Application for a Non-Material Amendment Following a Grant of Planning Permission

Outline planning application for the construction of up to 125 dwellings with public open space, landscaping and sustainable drainage system and vehicular access point from Highmoor Park. All matters reserved except for means of access.

3/2020/0601

We wish to amend the wording of the first paragraph only of condition 12 so that it reads as follows:

client: morris homes
 project: highmoor farm, clitheroe
 project number: J329224
 scale: 1:500@A3
 drawing title:
 preliminary site access
 drawing number:
 J32-9224-PS-001

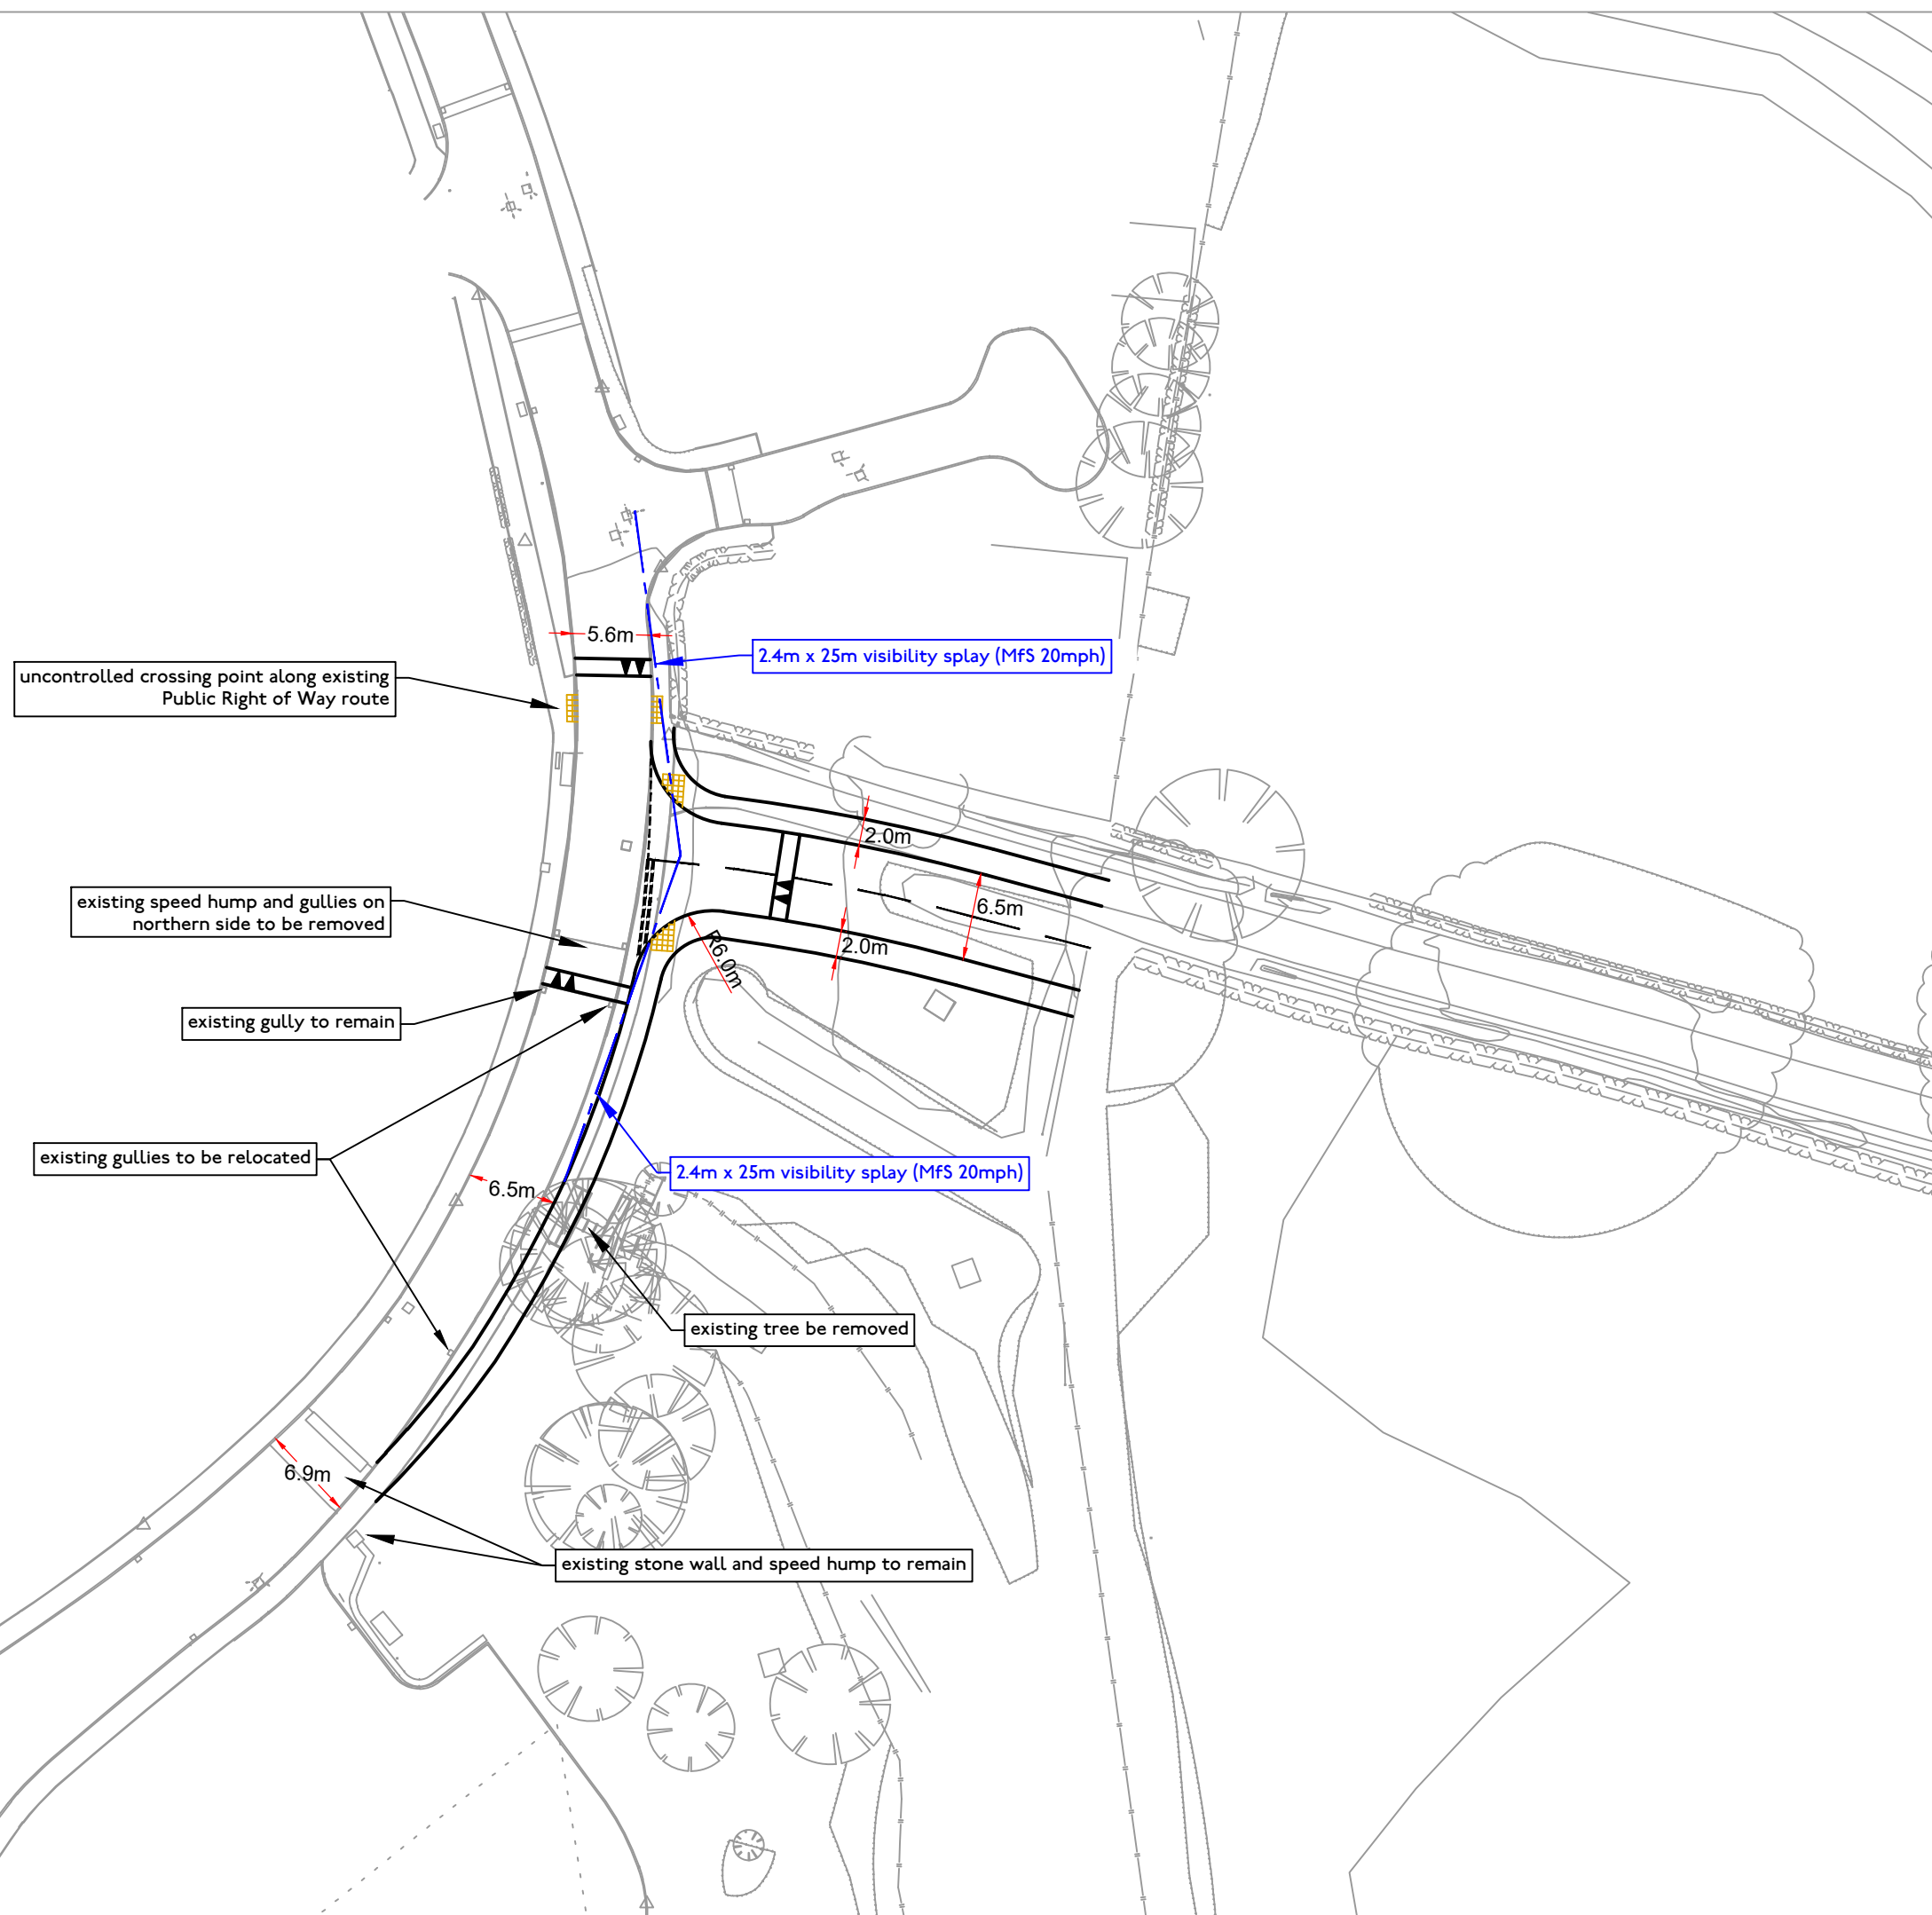
No part of the development hereby approved shall commence until a scheme for the construction of the site access, in accordance with approved Plan Ref J32-9224-PS-001 (Mode Transport Planning) Rev C 5/5/2026, and the off-site works of highway improvements has been submitted to, and approved by, the Local Planning Authority.

The proposed access from the site to Highmoor Park shall be constructed to a width of 6.5m with 2m footways on either side. As shown on approved Plan Ref J32-9224-PS-001 (Mode Transport Planning) Rev C 5/5/2026.

No dwelling shall be occupied until visibility splays 2.4 metres back from the centre line of the access and extending 25 metres on the nearside carriageway edge in both directions have been provided at the access as shown on the approved plans, Ref J32-9224-PS-001 (Mode Transport Planning) Rev C 5/5/2026. Nothing shall be erected, retained, planted and / or allowed to grow at or above a height of 0.9 metres above the nearside carriageway level which would obstruct the visibility splay. The visibility splays shall be maintained free of obstruction at all times thereafter for the lifetime of the development.

Two amended access drawings were submitted to the LPA both with the same reference which left some uncertainty as to which was the approved plan without reference to the relevant email exchange between the highway engineer and LCC Highways. The amendments sought will remove any uncertainty and will provide clarity. In addition to this while communicating with LCC Highways they advised us that the width of the proposed access road and the extent of the visibility splay required could both be reduced which is now reflected in the wording above and the plan submitted with this application.

Plan Ref J32-9224-PS-001 (Mode Transport Planning) Rev C 5/5/2026
